From: PAUL REED <[REDACTED]>
Sent: 06 November 2020 16:43
To: Nicola Moore
Subject: Re: Request for further information M/83/20/PL
Attachments: 206 rev C Proposed Ground Floor Plan 100 scale.pdf; 205 rev C Proposed Ground Floor in Context First Floor and Roof Plan 200s.pdf; 204 rev C Comparative Plans.pdf; 302 rev D Proposed East and West Elevations and Site Section.pdf

PROPOSED GROUND FLOOR
SITE PLAN IN CONTEXT, FIRST
FLOOR & ROOF PLANS
1:200

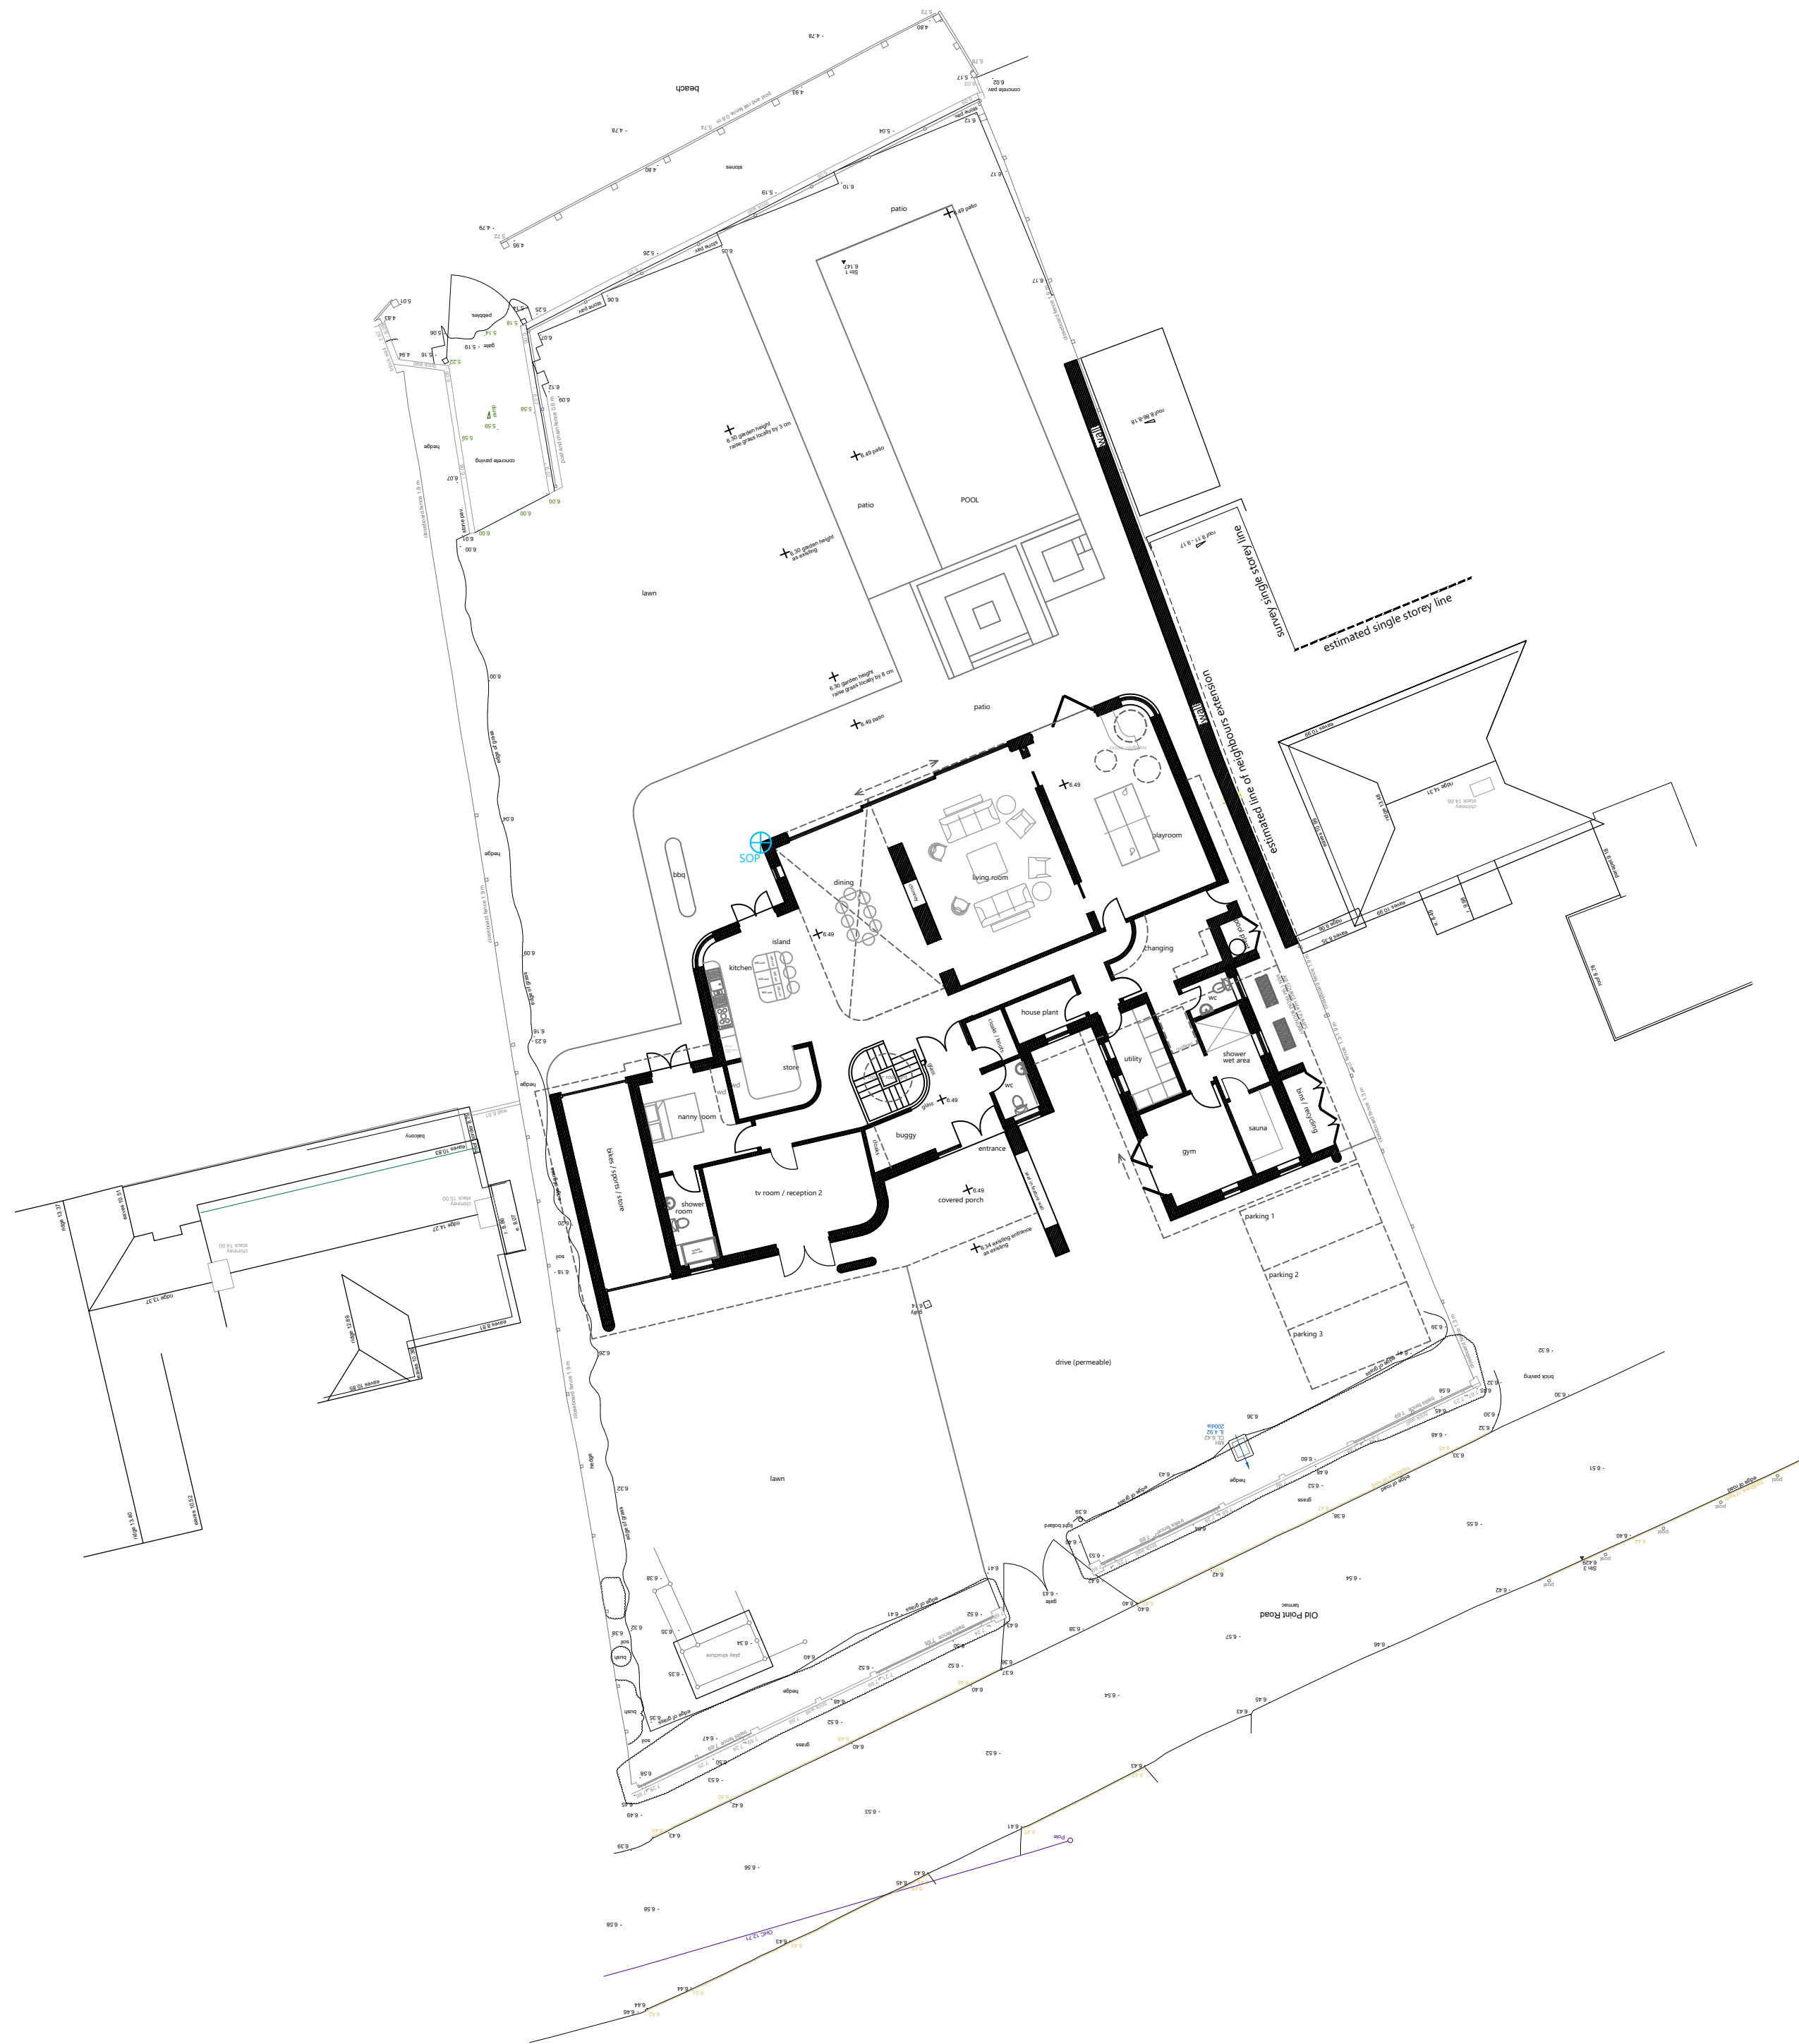
If you can amend the plan to include the door in front of the bin store to match the elevations and send to me as a PDF that would be great.

This would mean just adding the door on the plan in front of the bin store. A slight oversight.

Attached are the updated ground floor plans, 205 and 206 as requested, I've added the bin store doors, also amended the pool plant door to show door swing.
